# CITY OF ALBUQUERQUE

**Re: Fabrica en la Quinta/PHASE1**  
**1715 5<sup>TH</sup> St. NW**  
**30-Day Temporary Certificate of Occupancy**  
**Transportation Development Final Inspection**  
Architect's Stamp dated 06-08-22 (H14-D100A)  
Certification dated 06-30-23

1 Site Plan
 Scale: 1" = 20'-0"

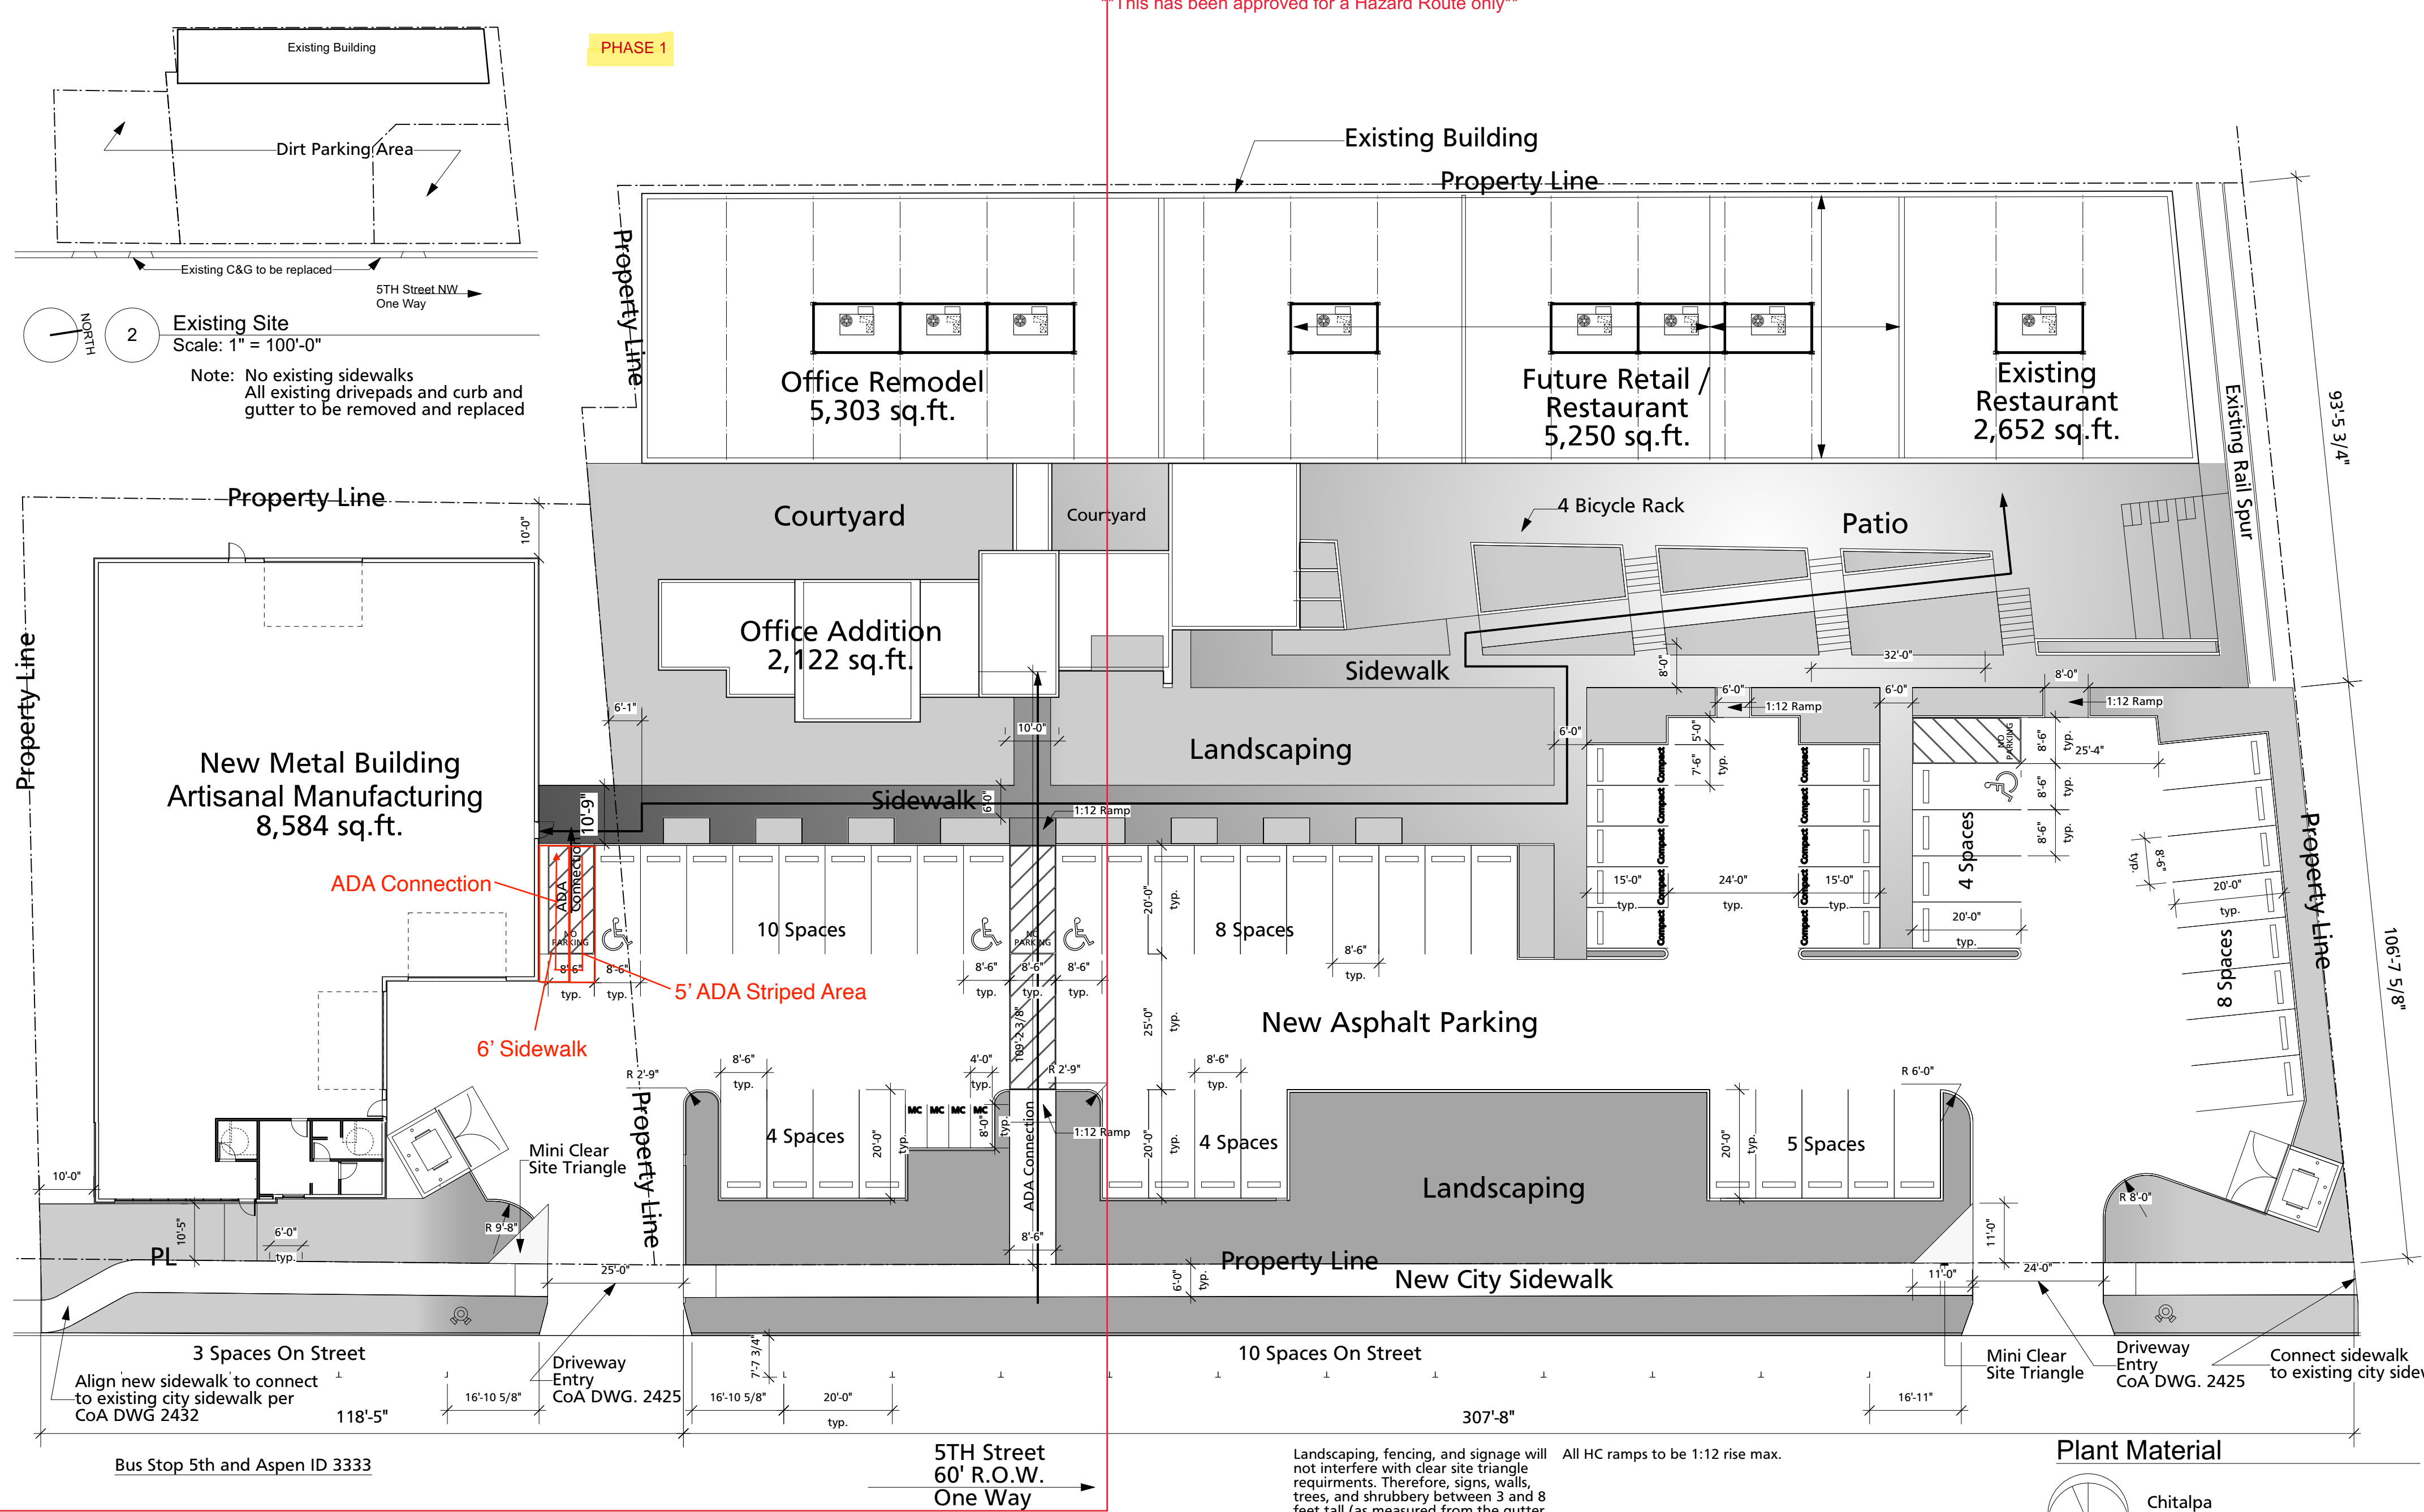
- Per approved site plan, please provide an ADA connection from the ADA parking aisle to the building entrance.
